DECISION DELEGATED TO HEAD OF PLANNING
--

Application No:	H09-0578-25	Applicant:	Keys Group
Proposal:	Proposed Boundary Fencing		
Location:	River Cottage Leadenhall Road Holbeach St Marks		
Terminal Date:	1st October 2025

Proposed Fence Elevations

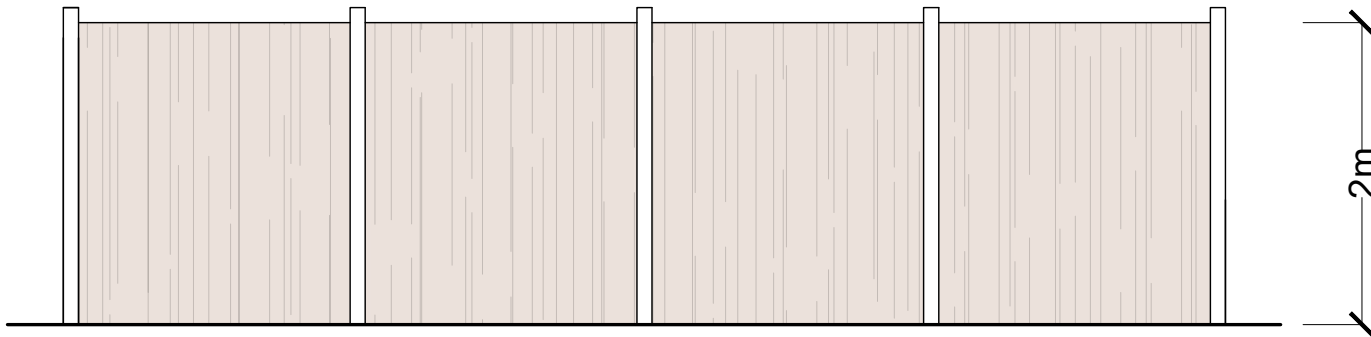
The proposal seeks to install 2m high close boarded fencing around the perimeter of the site, which features a detached dwelling. The posts of the fencing measure 2.1m in height. The nearest dwelling is Long Acre, which is located approximately 50m from the site boundary. It is not considered that the proposed fencing would have a detrimental impact on the amenity of Long Acre. Furthermore, permitted development rights allow for the installation of 2m high fencing on land that is not adjacent to a highway. Therefore, it is likely that the fencing could be installed using permitted development rights.

South Holland Internal Drainage Board has objected to the application as the fencing would be within 9 meters of the Board's watercourse (Holbeach River). The Board has byelaws which resist the placement of fencing within 9m of their assets as they need to maintain adequate space for maintenance.

Whilst the Board's objection is noted, in this case the proposed fencing would be permitted development in planning terms if the posts were 10cm lower in height. Fencing can be erected on land if the fencing is 2m or lower and if the fencing is not adjacent to a highway. The Board's objection has been discussed with the applicant's agent during the determination of the application and the Local Planning Authority has notified the agent that the Board require the fencing to be removed if it is installed without a compromise being negotiated.

As the fencing is borderline permitted development, it is not considered reasonable for the LPA to refuse the application. Furthermore, the agent has set out that they would be willing to reduce the height of the posts to 2m to enable the fencing to become permitted development. It is considered appropriate to include an informative reiterating that the Board have objected to the placement of the fence and that the Board have byelaws which could require the removal of the fence if installed. Therefore, it is recommended that the applicant contact the Board to try to negotiate the placement of the fence or to consider moving the fence further from the watercourse to avoid conflicting with the Board's Byelaws.
